January 3, 2022

**RE: New Mexico United Locker Room
5601 University Blvd. SE
Grading and Drainage Plan
Engineer's Stamp: None
Hydrology File: R15D002A**

Based upon the information provided in your submittal received 11/23/2021, the Grading and Drainage Plan can't be approved for Building Permit until the following comments are addressed:

No	Date	Description
Revision Schedule		
ISSUE:		CD's
PROJECT #:		61257
FILE:		
DRAWN BY:		JW
CHECKED BY:		JW
DATE:		12.03.21
GRADING AND DRAINAGE PLAN

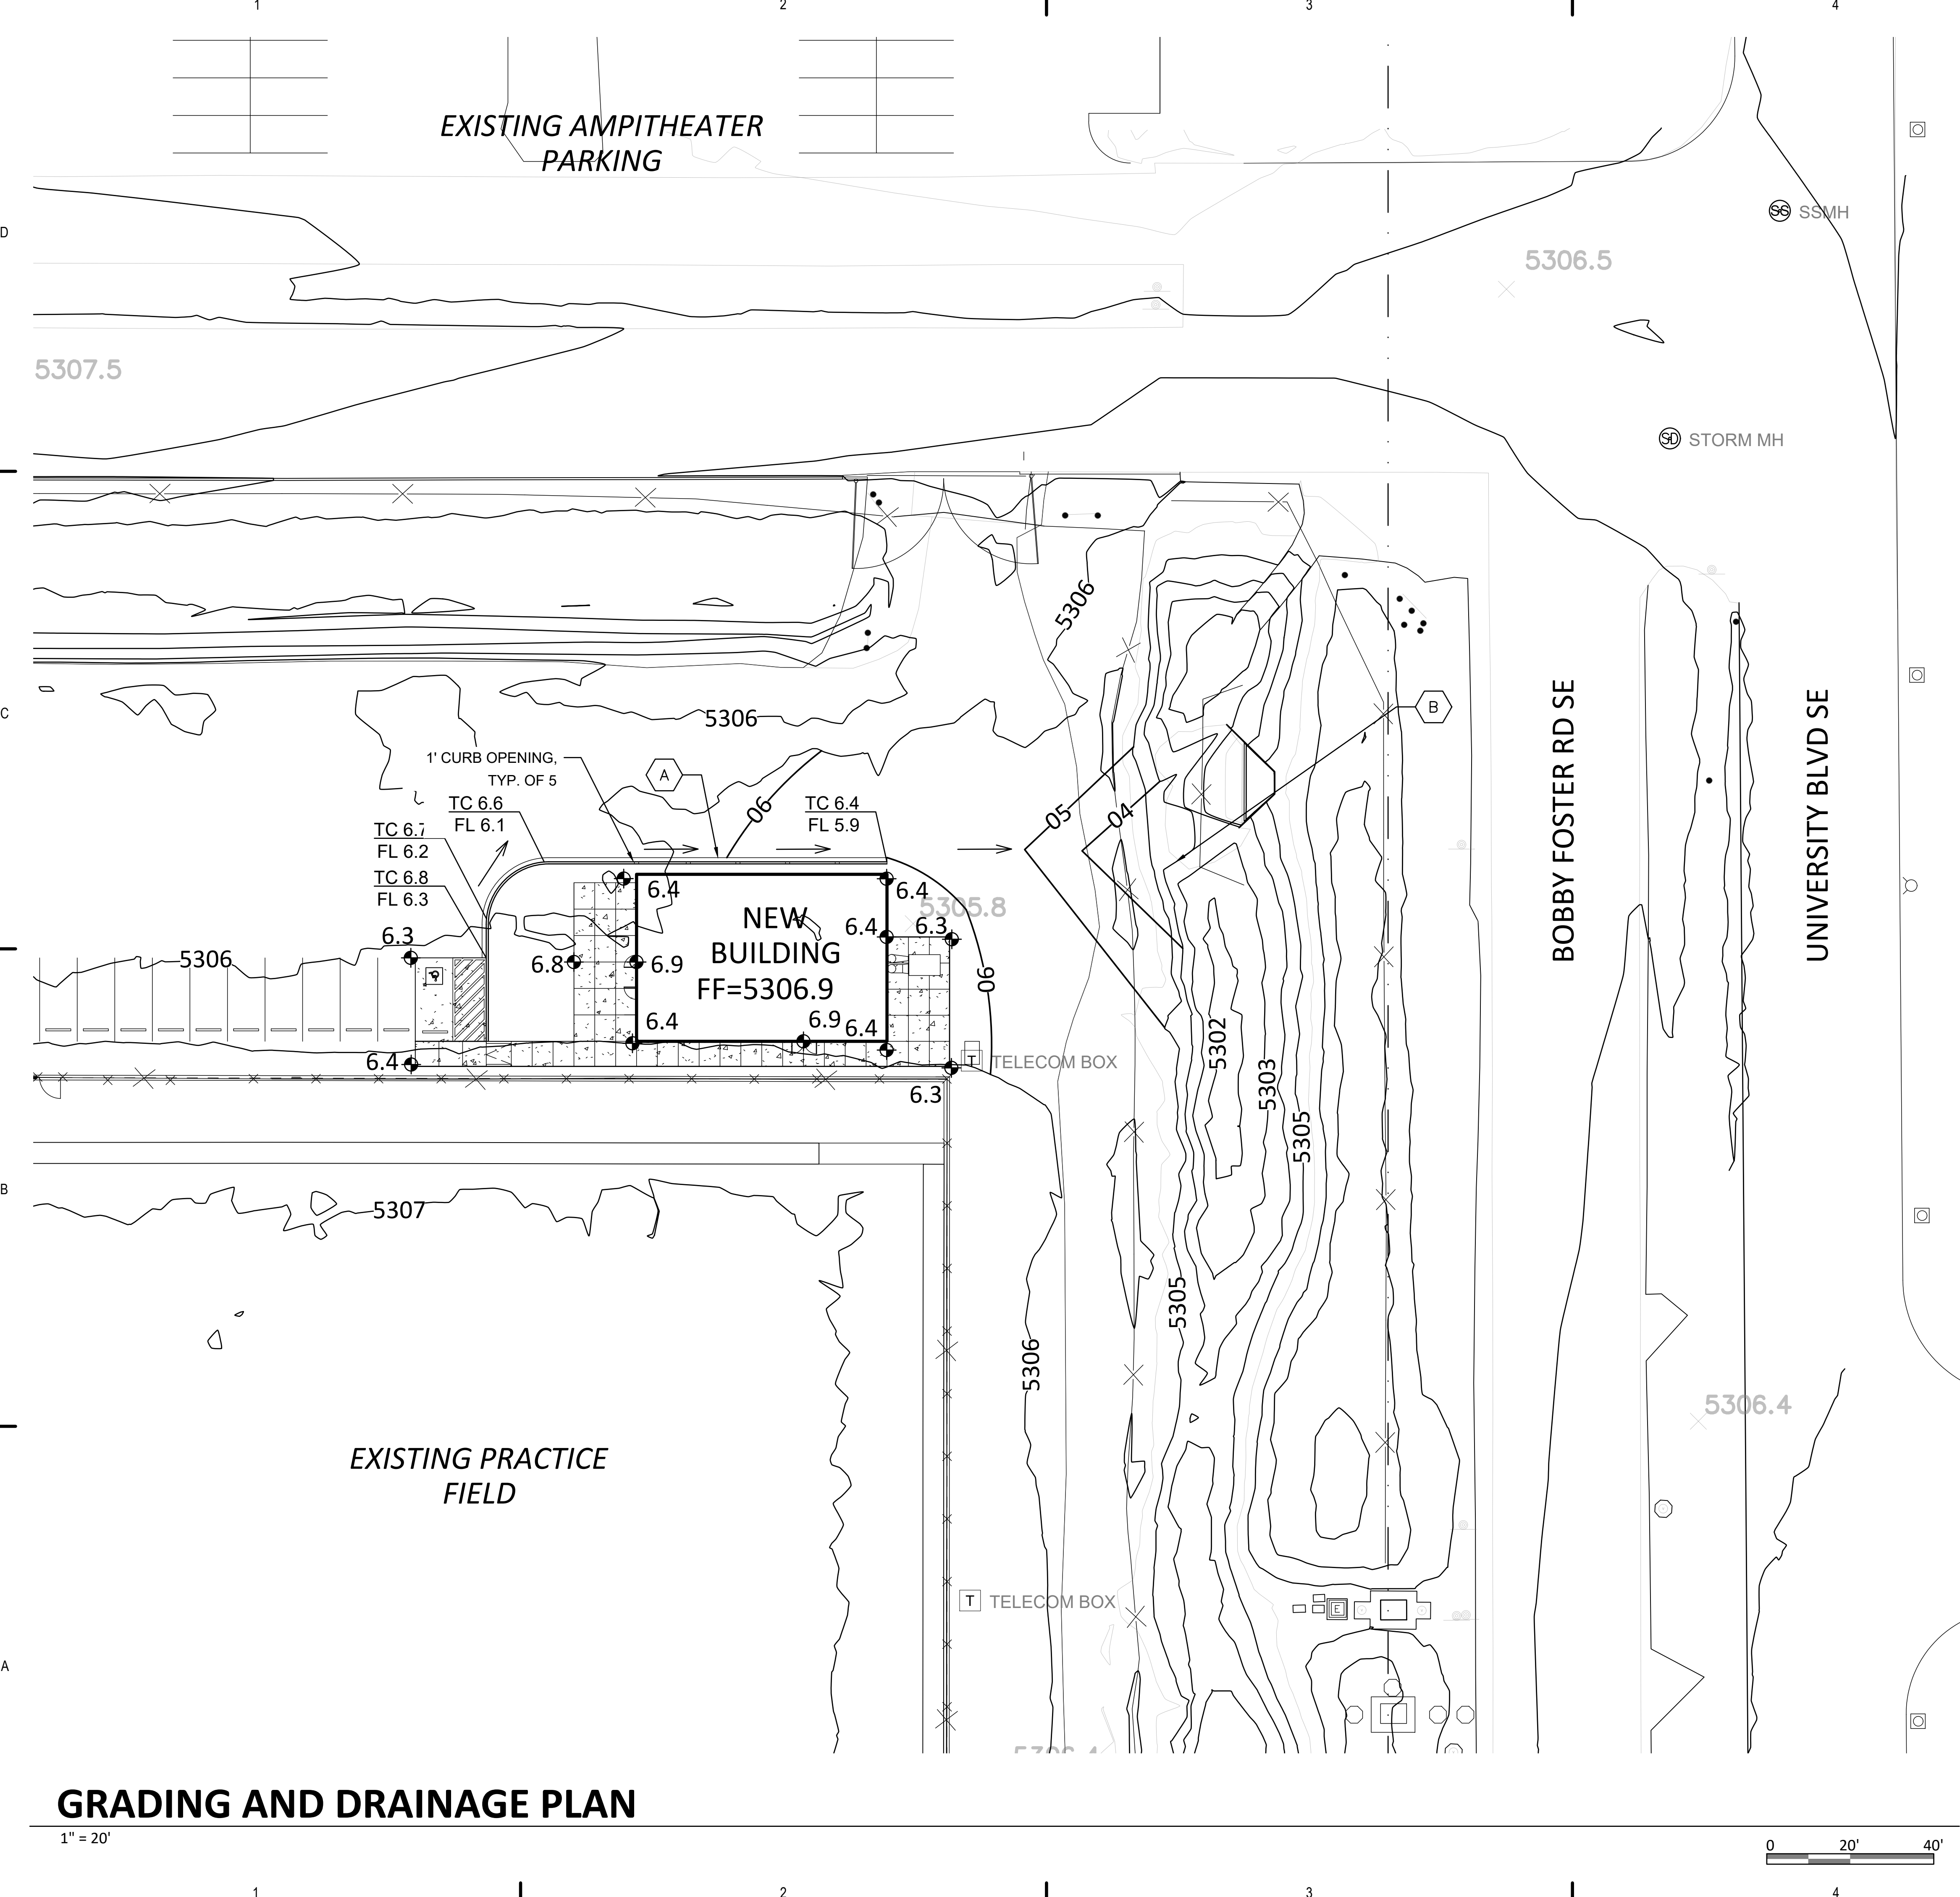
3. The narrative describes flows captured by an existing ditch, but does not provide for the capacity of the ditch or where these flows ultimately will be detained/retained. You must demonstrate downstream capacity of flows leaving the site or ponding capacity if retained/detained onsite.

4. You provide overall existing basin calculations, but then only provide calculations for new sub-basins in the proposed conditions. As the new design reconfigures the flow characteristics with the new basins crossing existing basin lines, you must provide total overall total existing and proposed calculations so we can compare existing versus proposed.

5. There has been a new submittal for a new storage building at the northeast corner of the field within Basin 101. Please coordinate with Scott McGee on his design and Grading and Drainage plan for this work so it can be incorporated with your overall site layout. I have also informed him to coordinate with you.

C-101

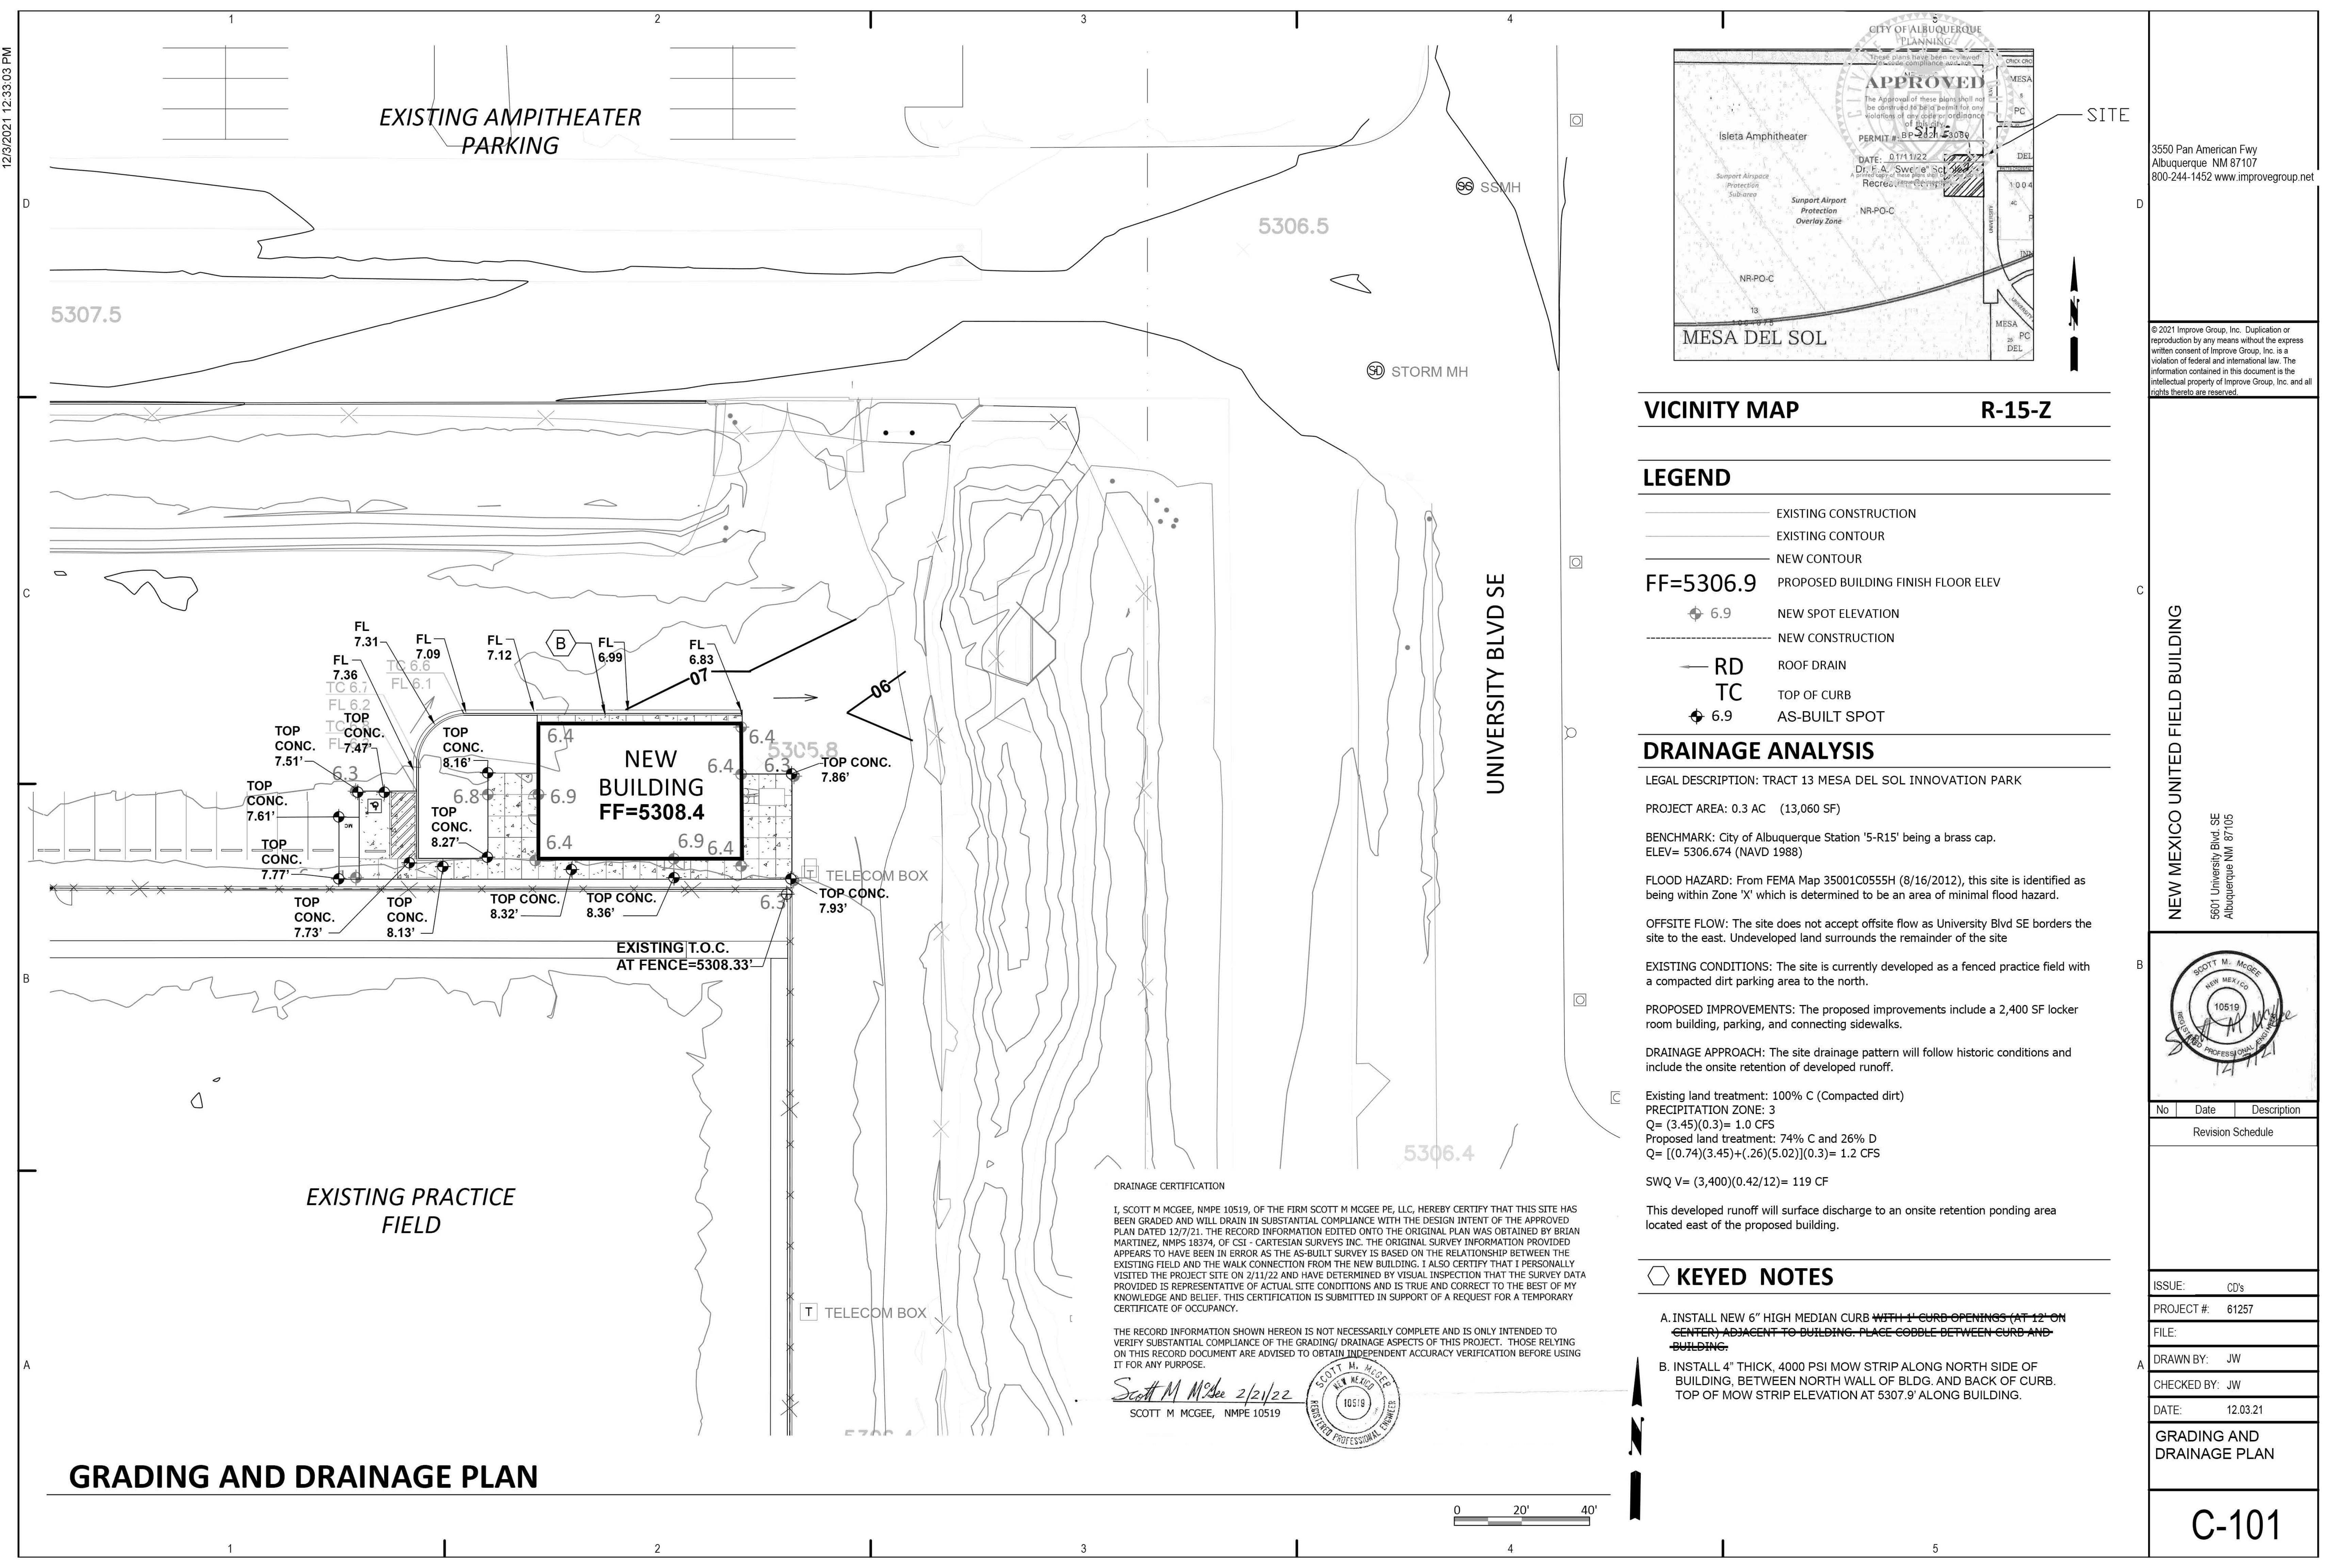
1. Please ensure the Grading and Drainage plan is stamped and signed by a NM Professional Engineer.
2. Please provide calculations for the required Storm Water Quality Volume (SWQV) and include on your plan where this volume will be ponded.
